Luminato, 169 Newbury Street - Updated Final Traffic Comments

Hi Caitlin – The following represents my final traffic comments.

**5 BITUMINOUS DRIVEWAY APRON (I-13)**  
NOT TO SCALE

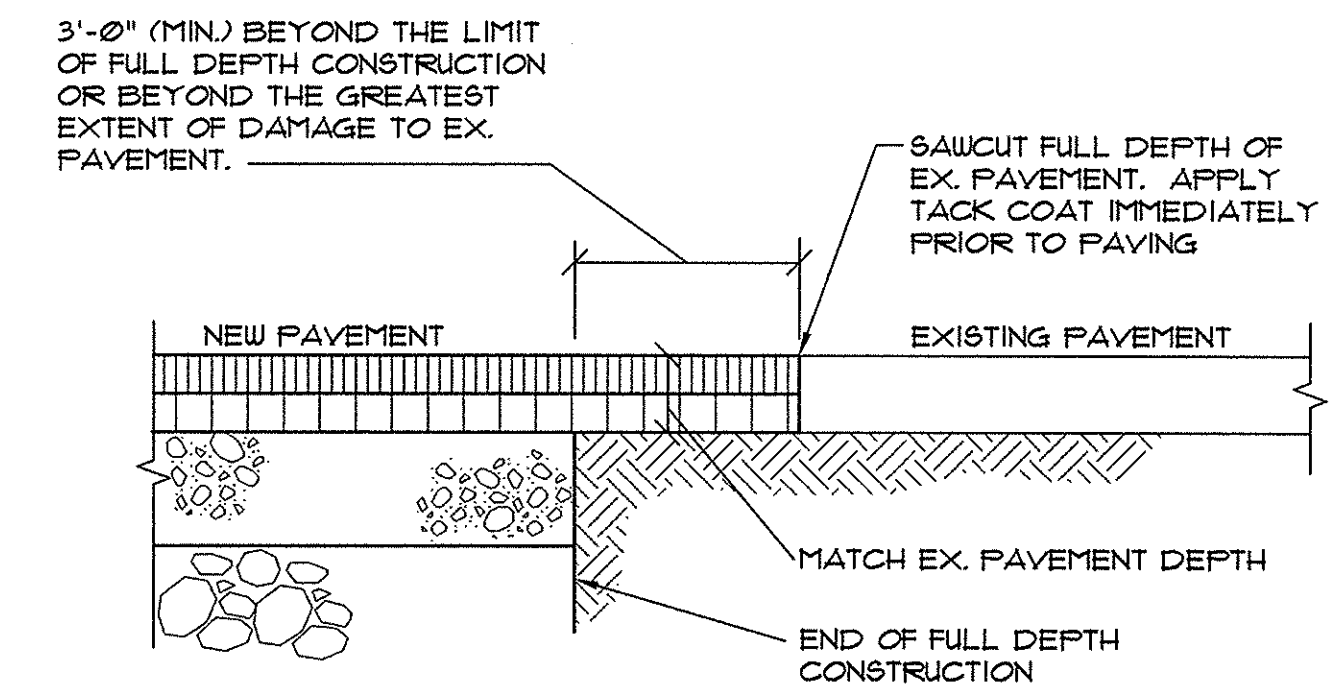
- The driveway apron on Newbury Street shall be designed so that a maximum 2% cross-slope is constructed for pedestrians walking along Newbury Street.

Final Status: A note has been added to the plan and I find it to be acceptable.

**2 DRIVEWAY APRON LAYOUT (I-9)**  
NOT TO SCALE

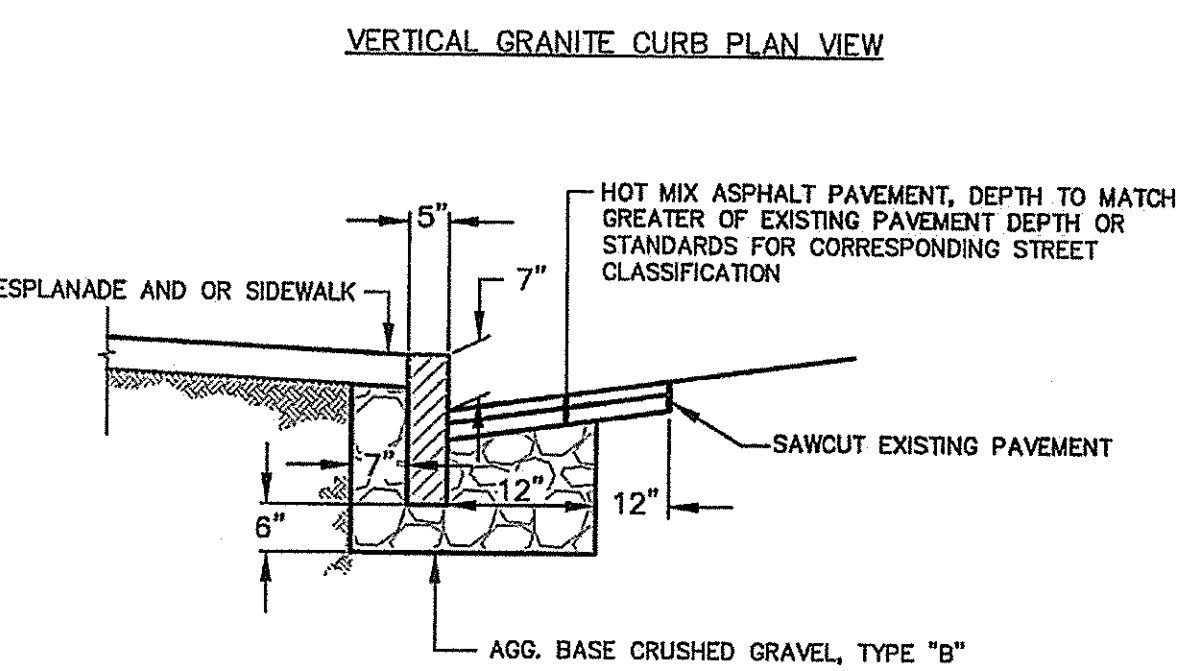
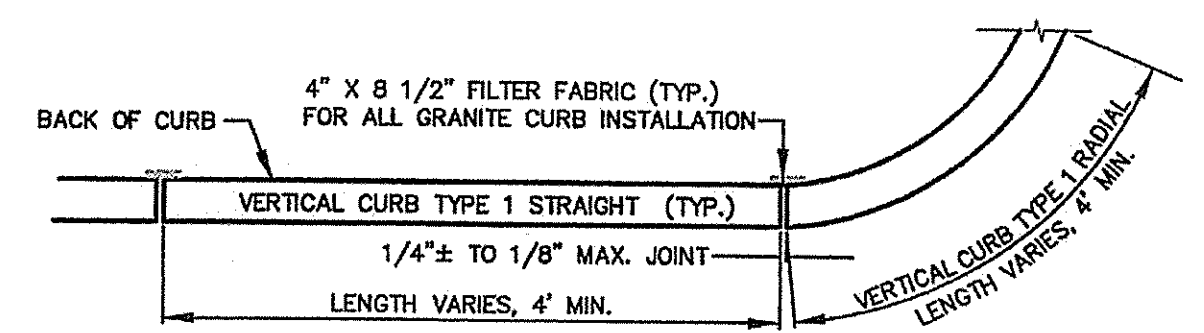
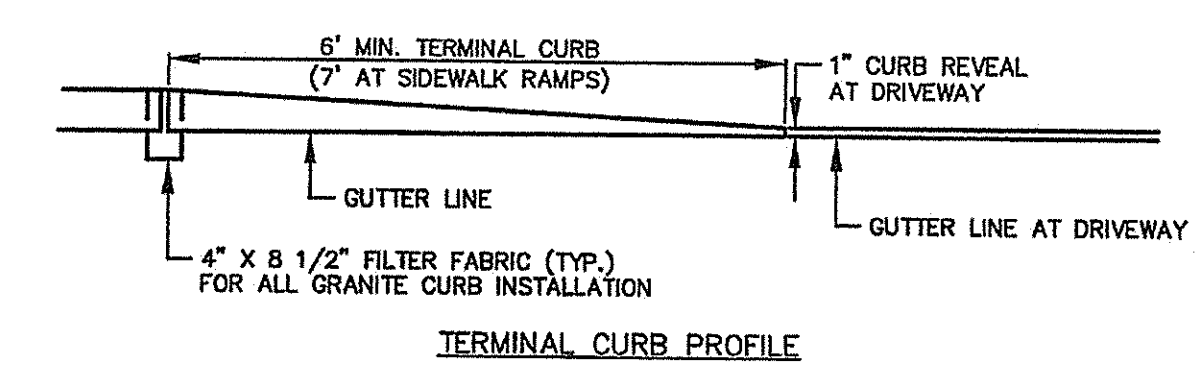
Final Status: I find the revised plan to be acceptable with the exception that the driveway width at the Federal Street curb line shall be 22-feet (a 2-foot taper from property line to curb line is the City standard). The Newbury Street driveway shall also meet City standards and include a 2-foot taper from the property line to curb line.
